Date: 10 February 2023
Our ref: 64091/02/SSL/PBu/26223331v2

Land at Austin Road, Hayes- Response to Comments Received on Application ref: 76550/APP/2022/3662

## Section Comparison

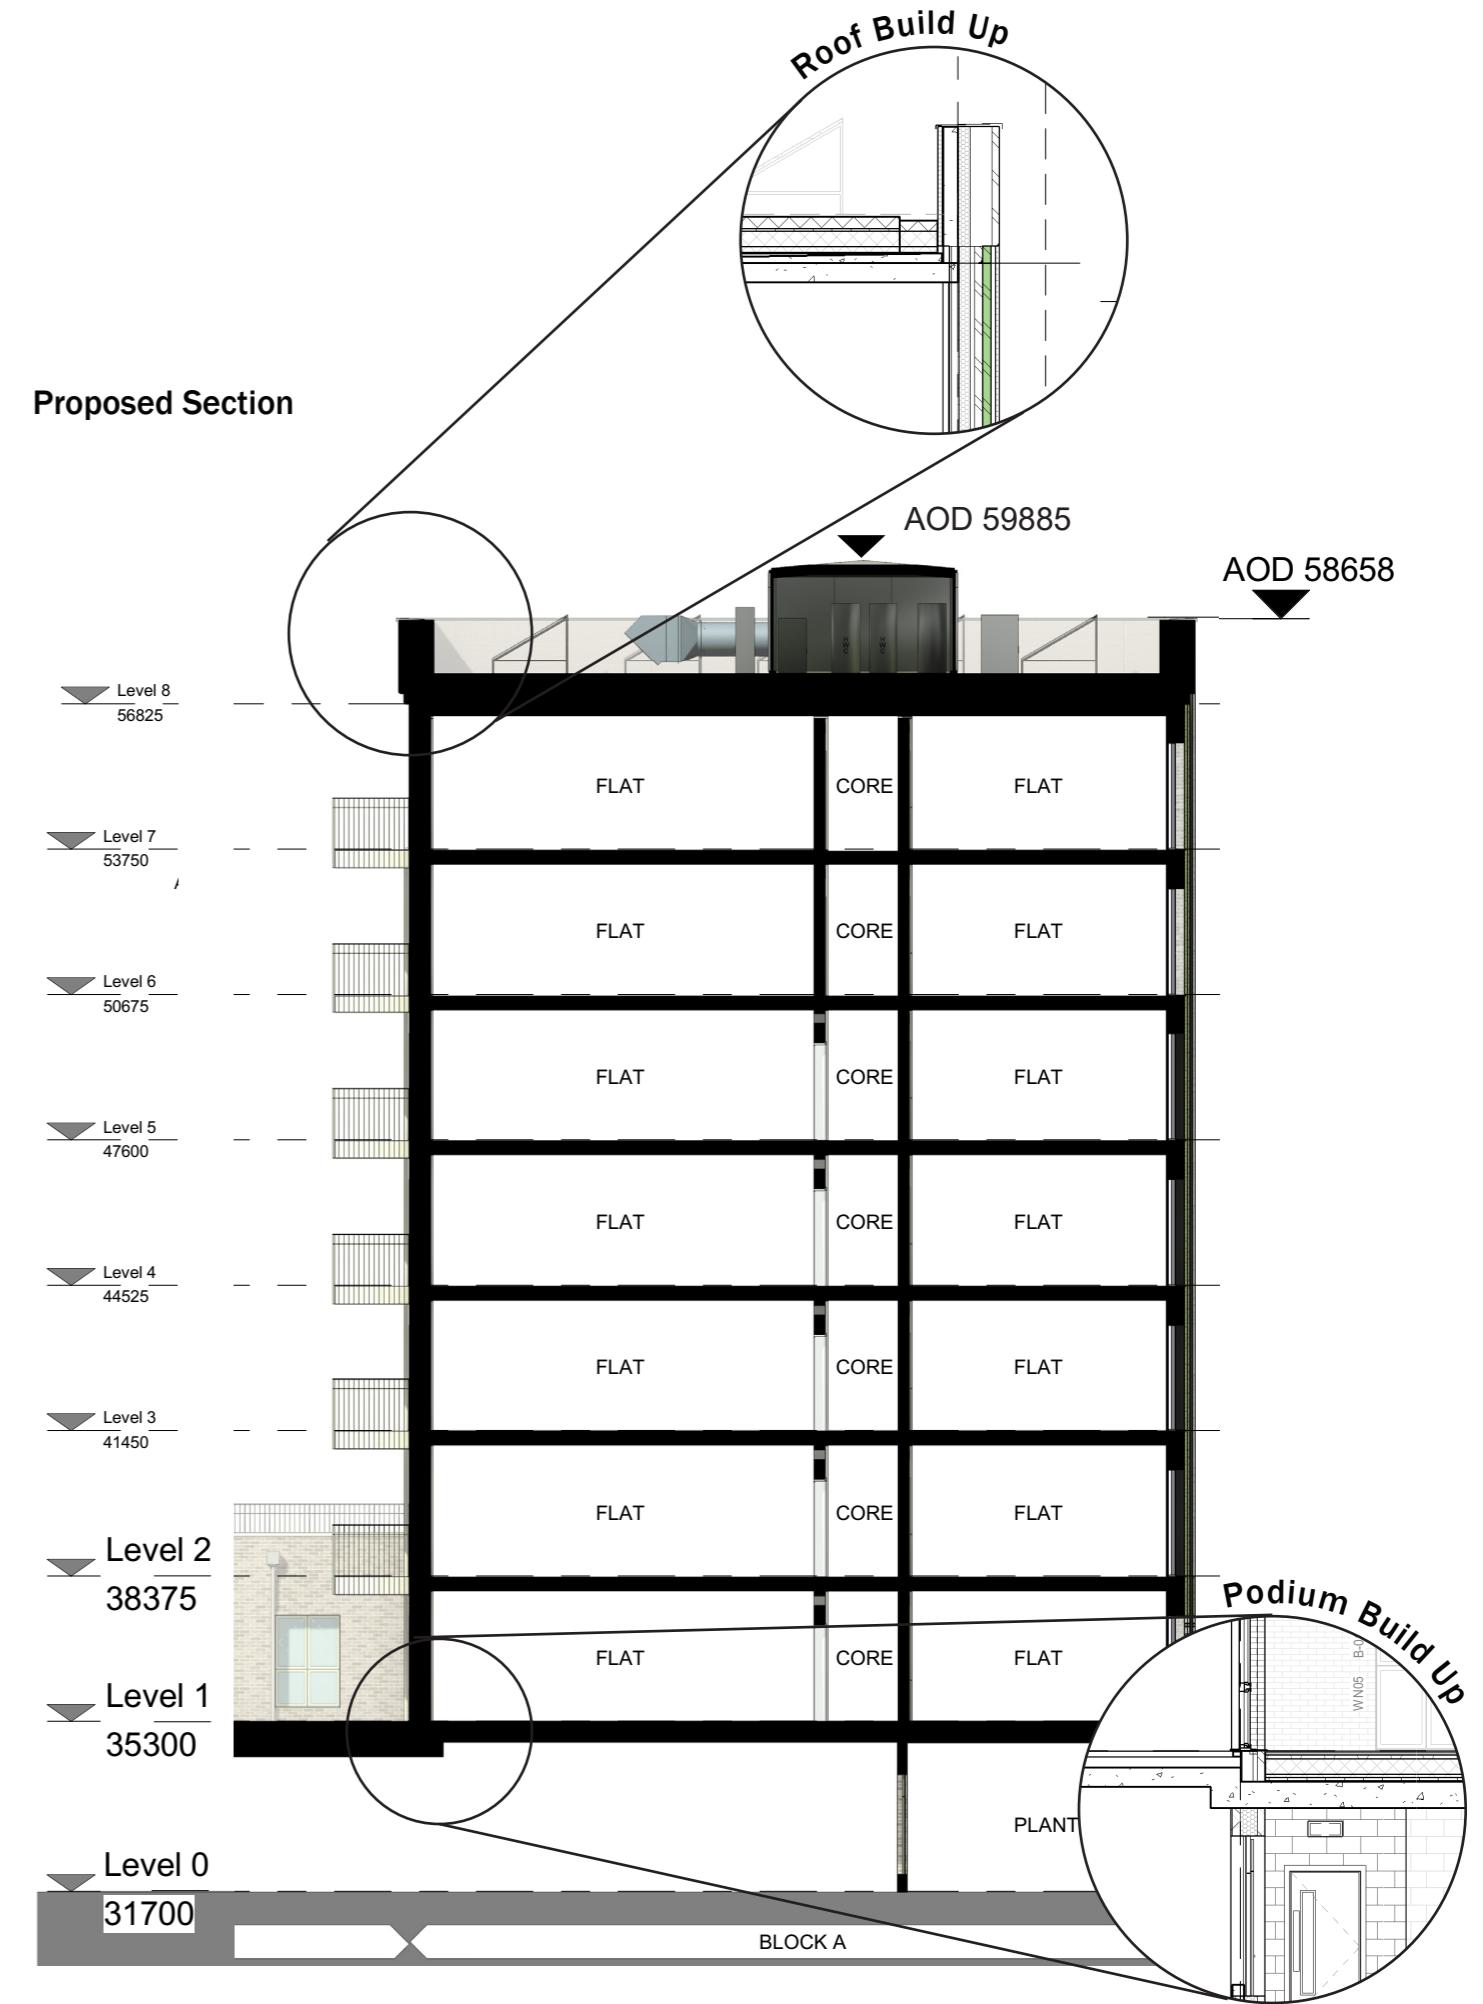
- 1 In response to your comments, the proposed parapet height has been reduced in height so that the highest point of the building is now slightly lower than in the consented scheme. This change is explained on page 21 of the updated Design and Access Statement and is reflected in the proposed drawings.
- 2 In response to changes in fire safety building regulations, changes are proposed to the core arrangement, lift size and window specification. As a result of these changes, small adjustments to the layout of apartments located closest to the core have also been made. These changes are shown on p. 15 and 27 of the DAS.
